From: Studio5 Architects [REDACTED]
Sent: 20 October 2015 16:51
To: David Easton
Cc: Robin Mincik
Subject: 15.903 10 Mariners Quay_LU/261/15/HH amended drwg 15.903-TP01C

Further to receipt of your recent comments on the submitted drawings for the alterations to 10 Mariners Quay, Littlehampton (ref: LU/261/15/HH), please see the attached drawing 15.903-TP01C which has been amended as follows:

SCALE	DATE
as shown@A1	Aug 2015
PROJECT NO.	DRAWING NO.
15.903	TP01C

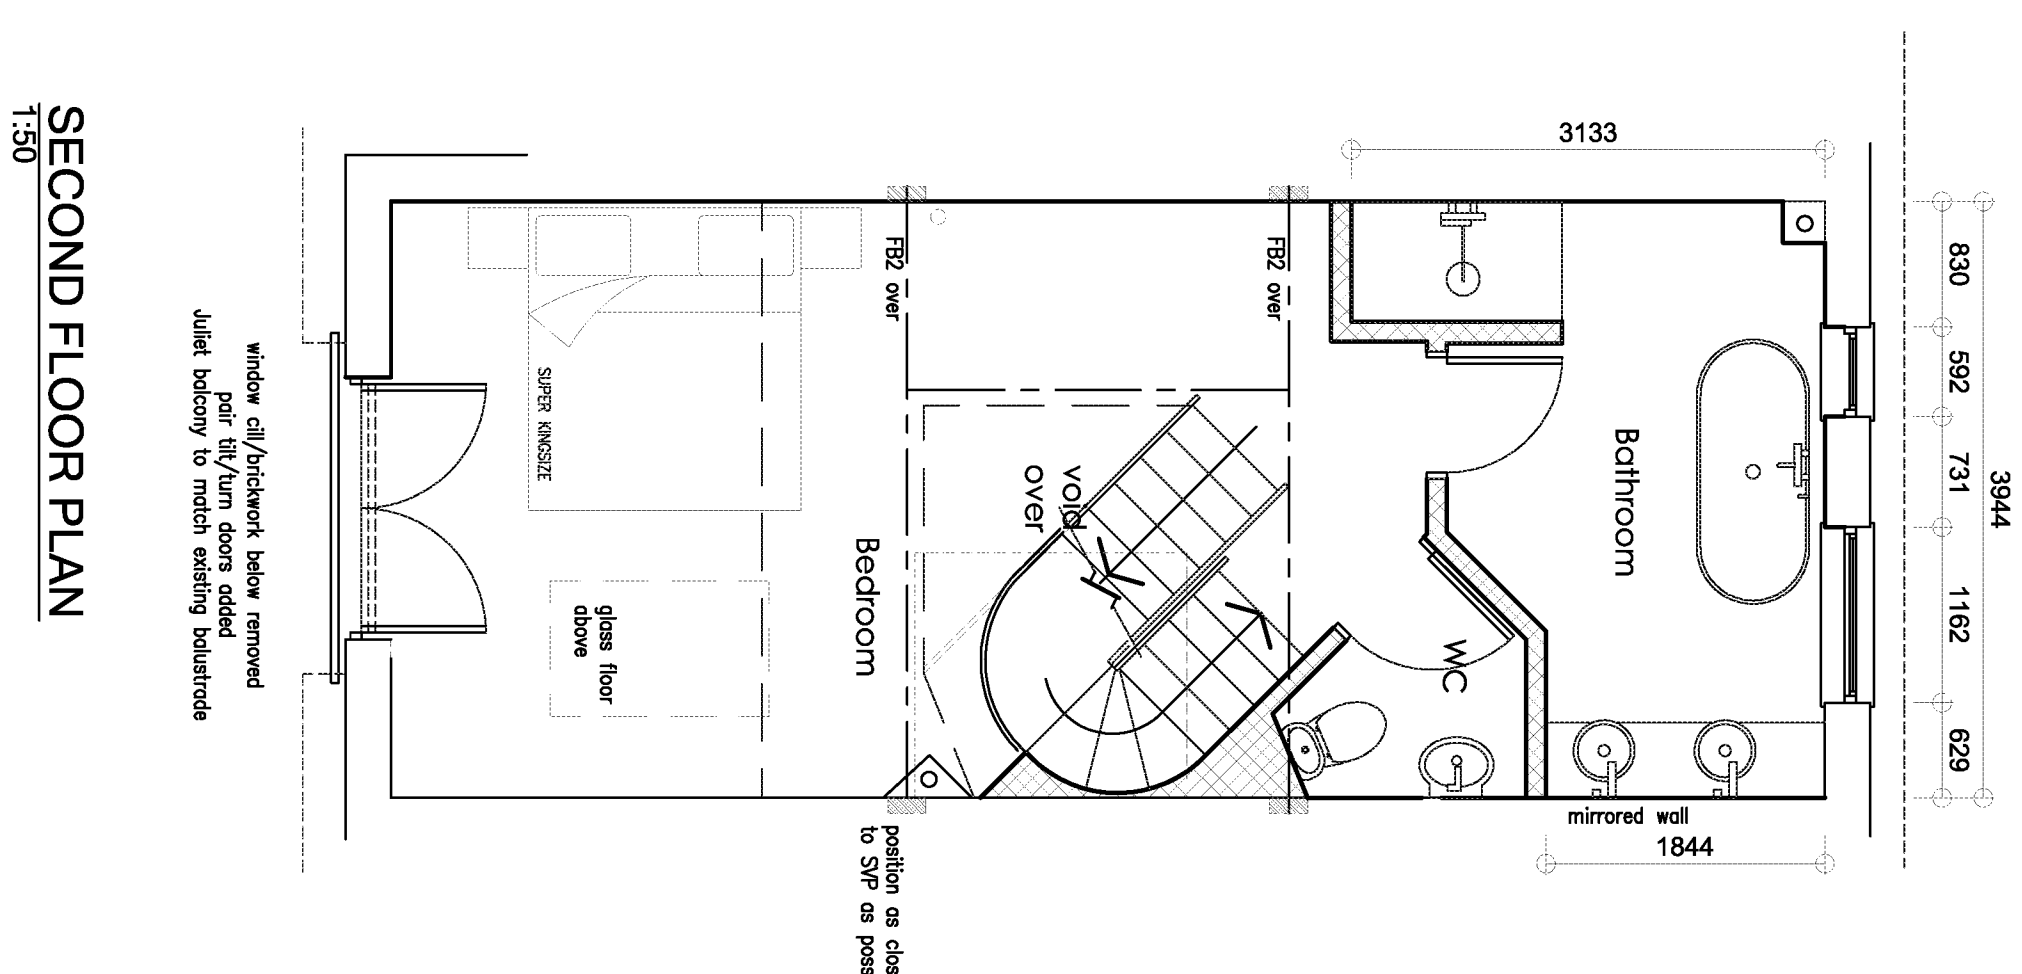
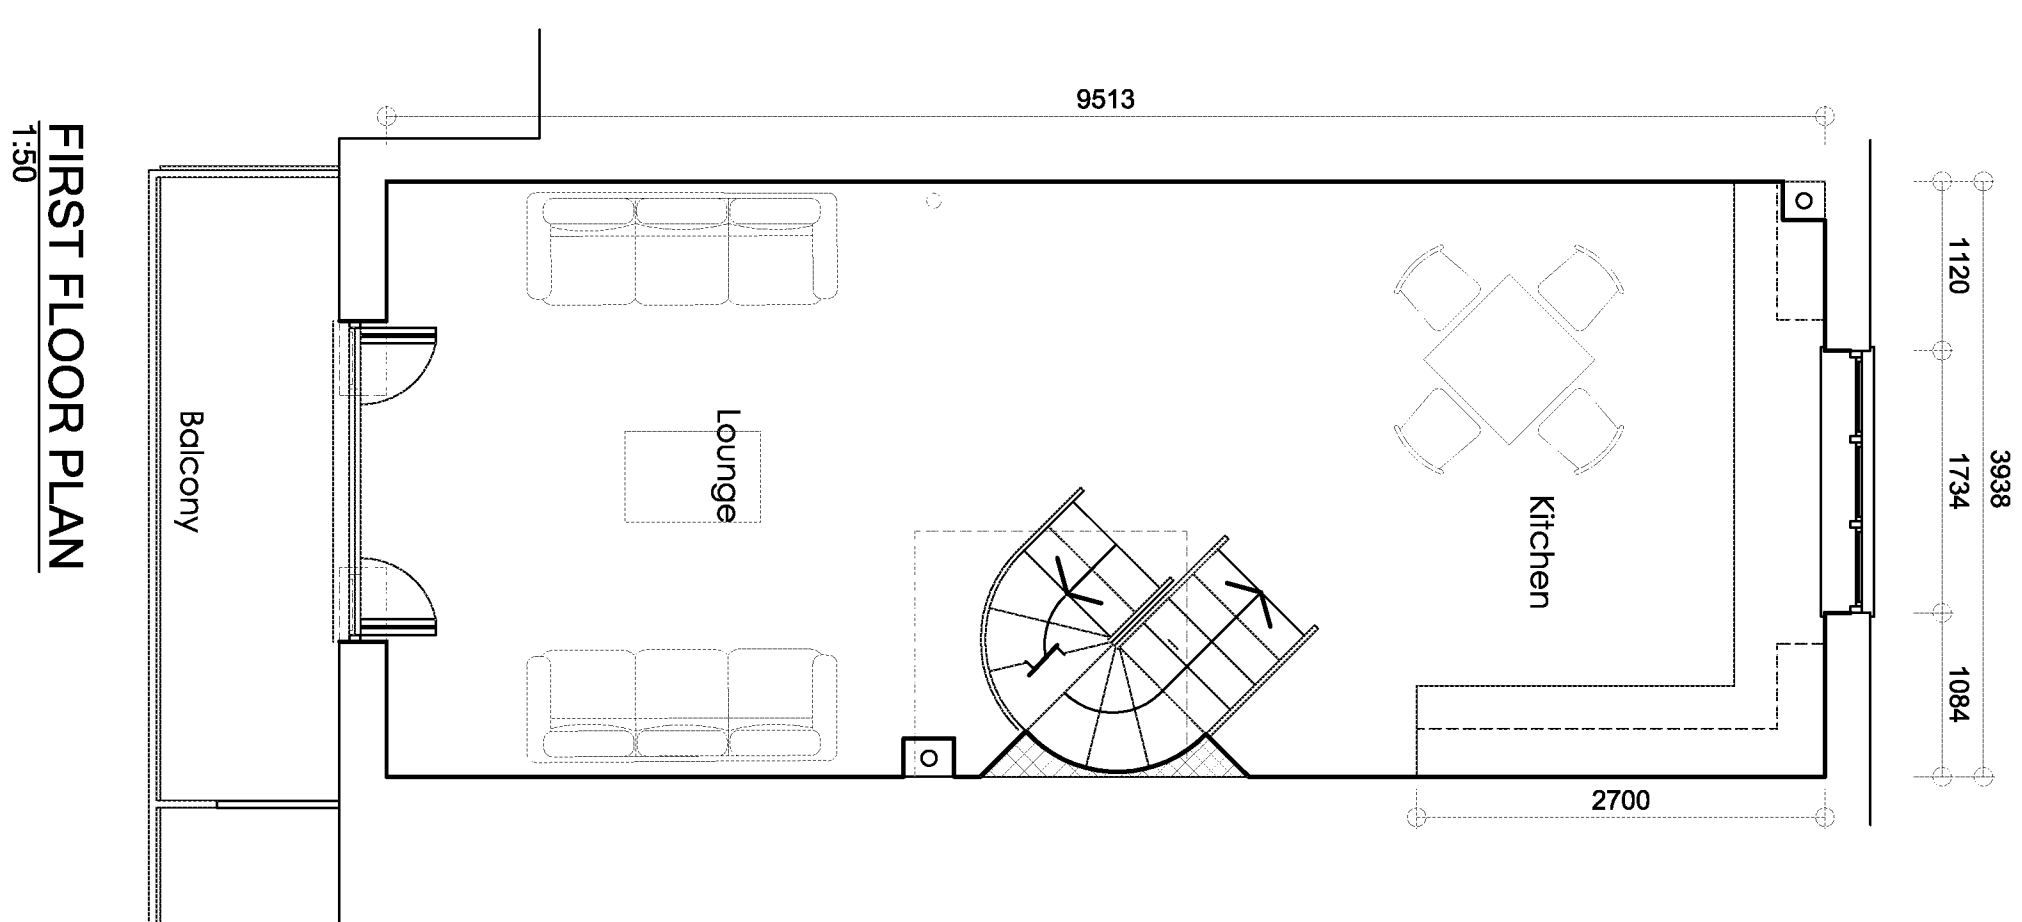
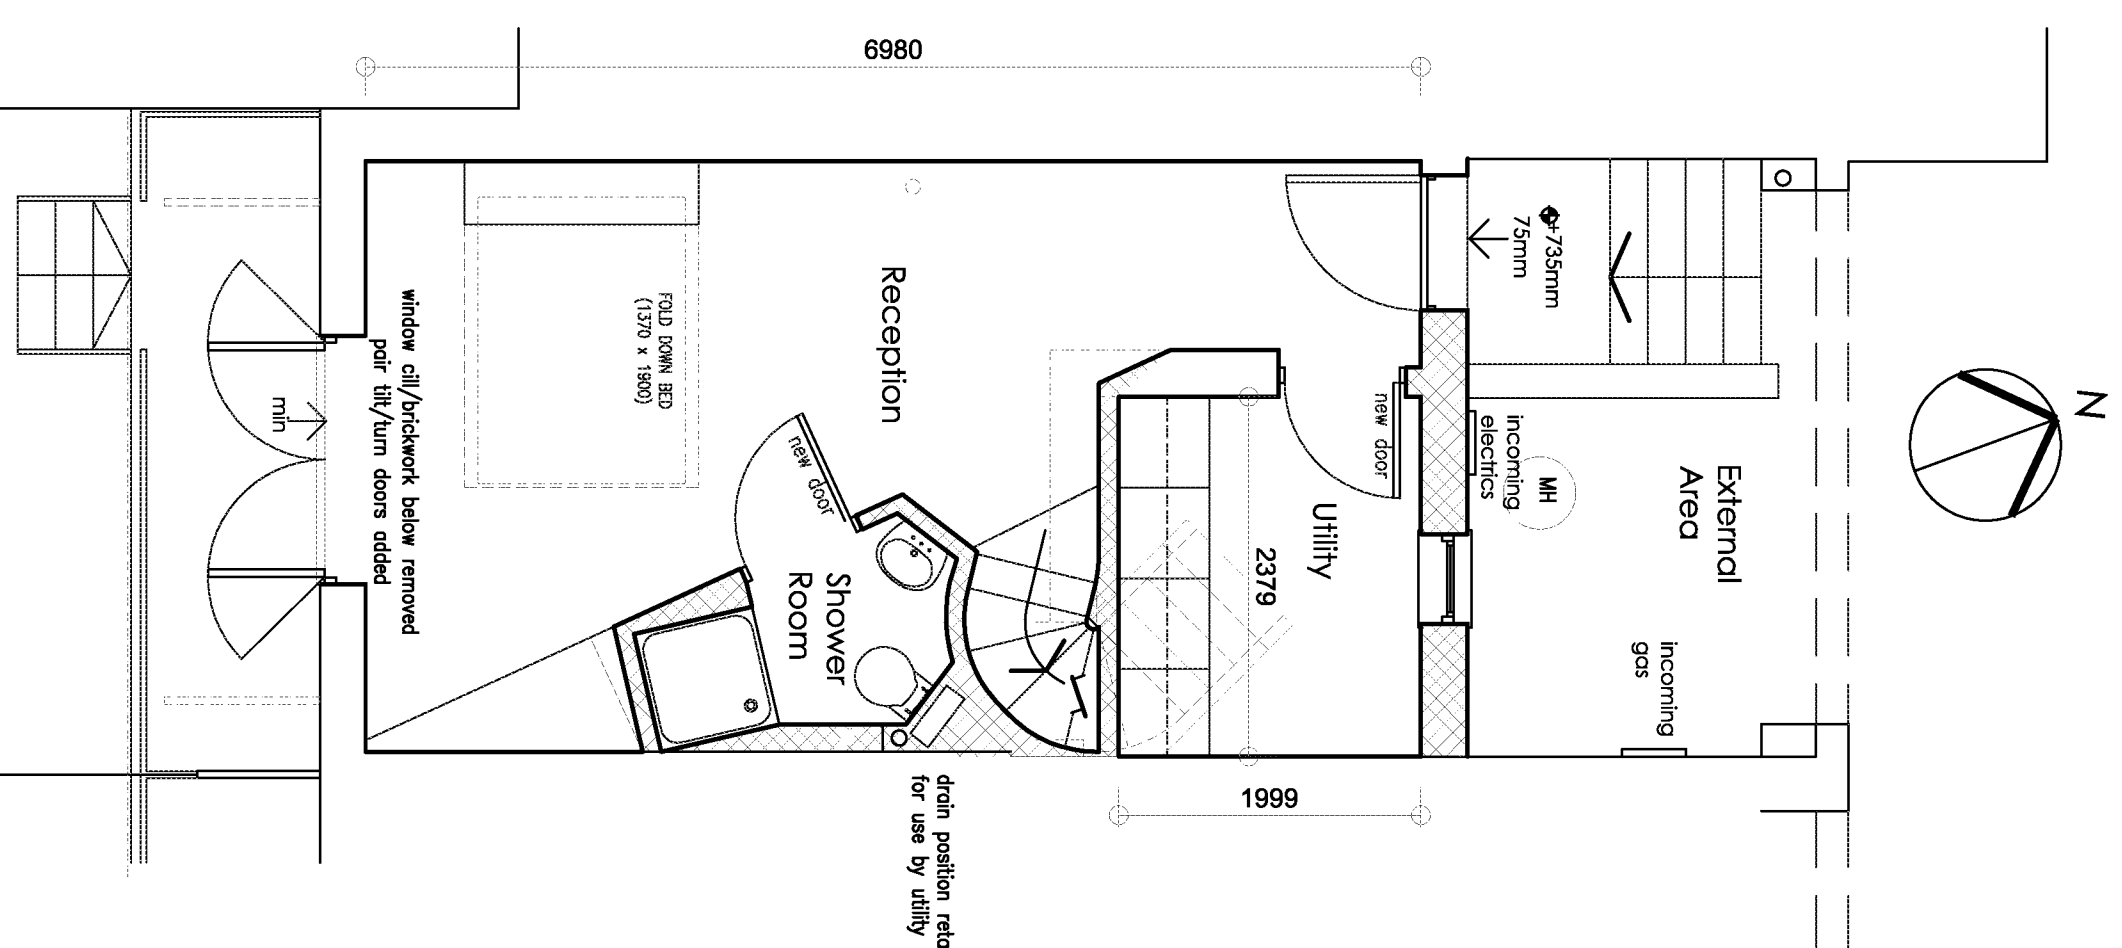
- Alterations to 2nd floor windows omitted
- Introduction of Juliette balcony omitted
- Extension of ground floor decking and handrails omitted
- Bathroom layout amended
- Utility window amended
